# Summary of Comments on 2103-257-SUB1-PLANS\_review.pdf

Page: 14

ROOF FRAMING PLAN

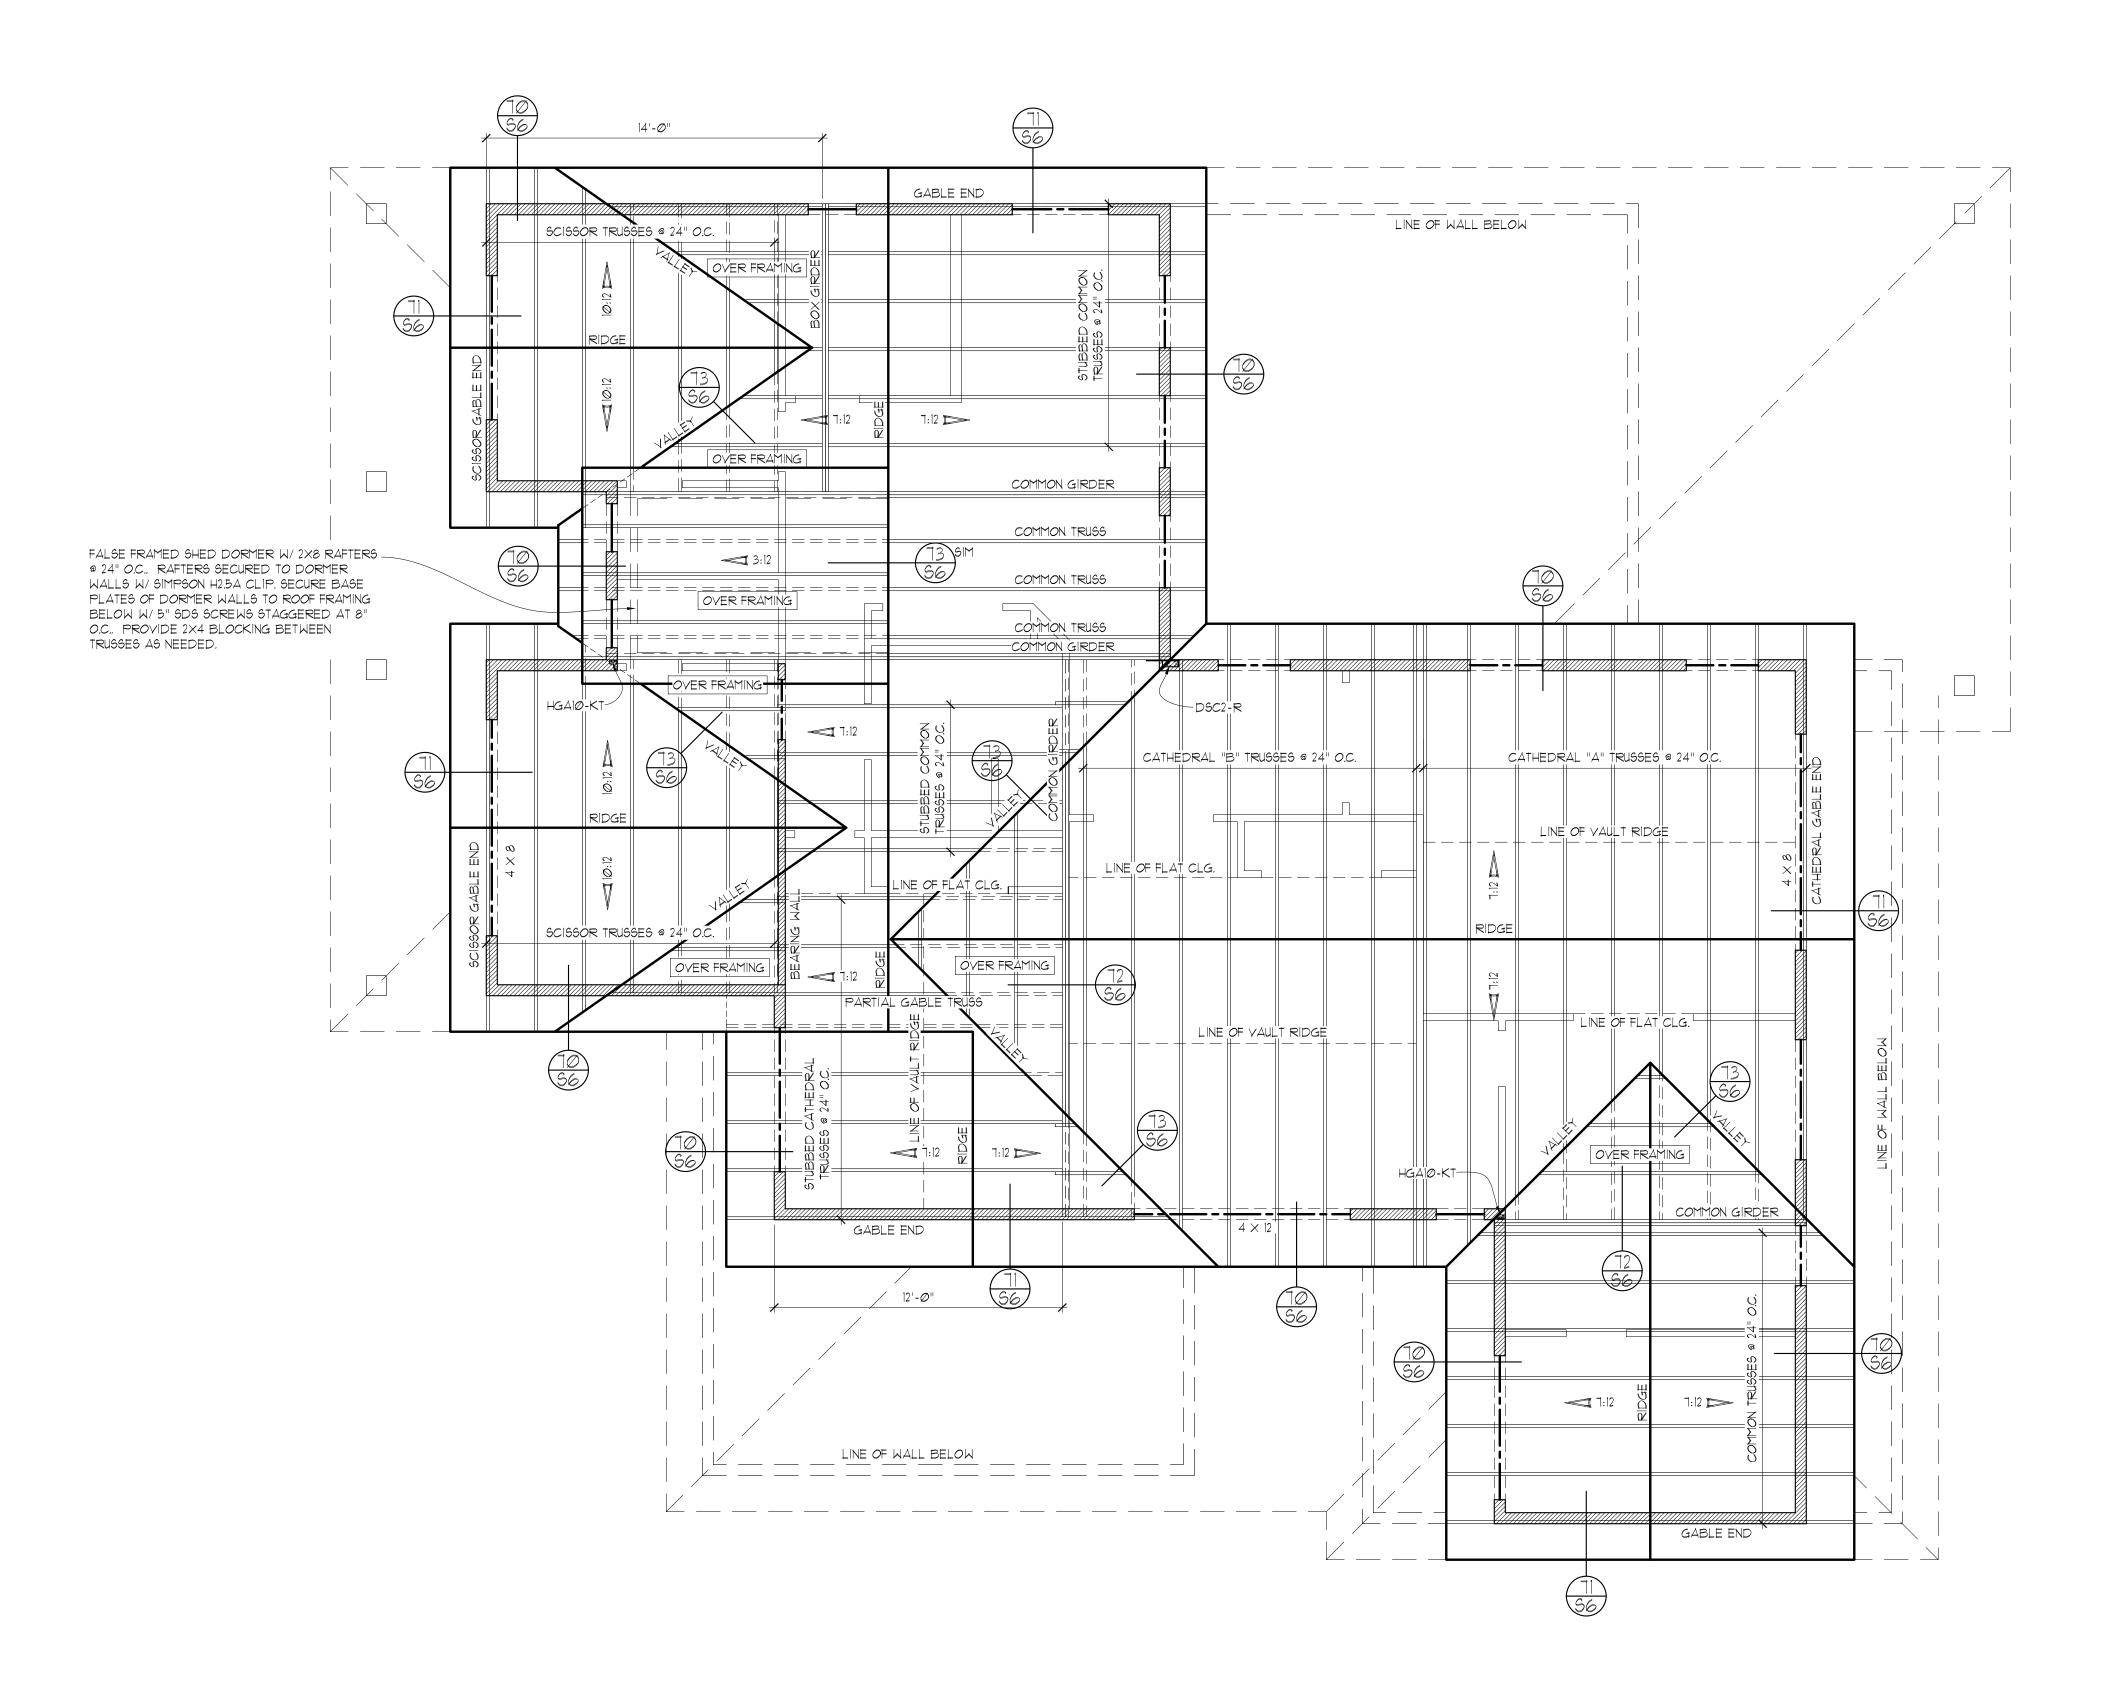
💬 Author: Building Review (paul.skidmore@mercergov.org) Subject: Comment Date: 7/9/2021 4:46:53 PM  
Indicate axial design force at all truss members acting as collectors / drag struts. Note minimum sheathing nailing requirements for all drag struts.

↩ Author: Mark Myers, PE (myengineer@centurytel.net) Subject: Sticky Note Date: 7/9/2021 4:47:36 PM  
We will add design force labels to appropriate members.

TYPICAL PAB ANCHOR BOLT (H5) SCALE: 3/4"=1"

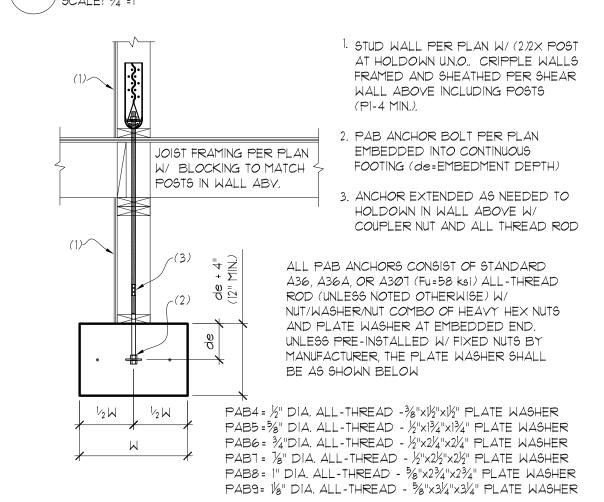
Standard PAB detail indicates a minimum footing depth of 12". Please coordinate with footing schedule.

Author: Mark Myers, PE (myengineer@centurytel.net) Subject: Sticky Note Date: 7/9/2021 1:51:28 PM

We have revised the foundation plan in response to other questions, and PAB anchors are no longer used at these locations.

CRIPPLE WALL FOR SLOPED LOTS

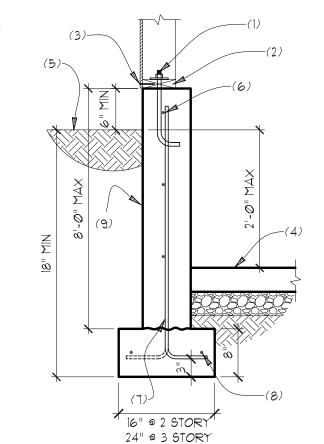
Confirm additional height of cripple wall does not overstress holdown.

Provide callout or detail holdown at crawl space conditions.

Good catch, we will revise the foundation plan to limit the distance between the holdown and the top of concrete to 18" maximum as required by Simpson Strong-Tie for maximum allowable loads.

A large note on S1 & S2 already directs framers and foundation contractors to the typical details for holdown straps and anchors located on S5. In response to one of your other questions, this condition has been revised to eliminate the PAB anchor and cripple walls at this location
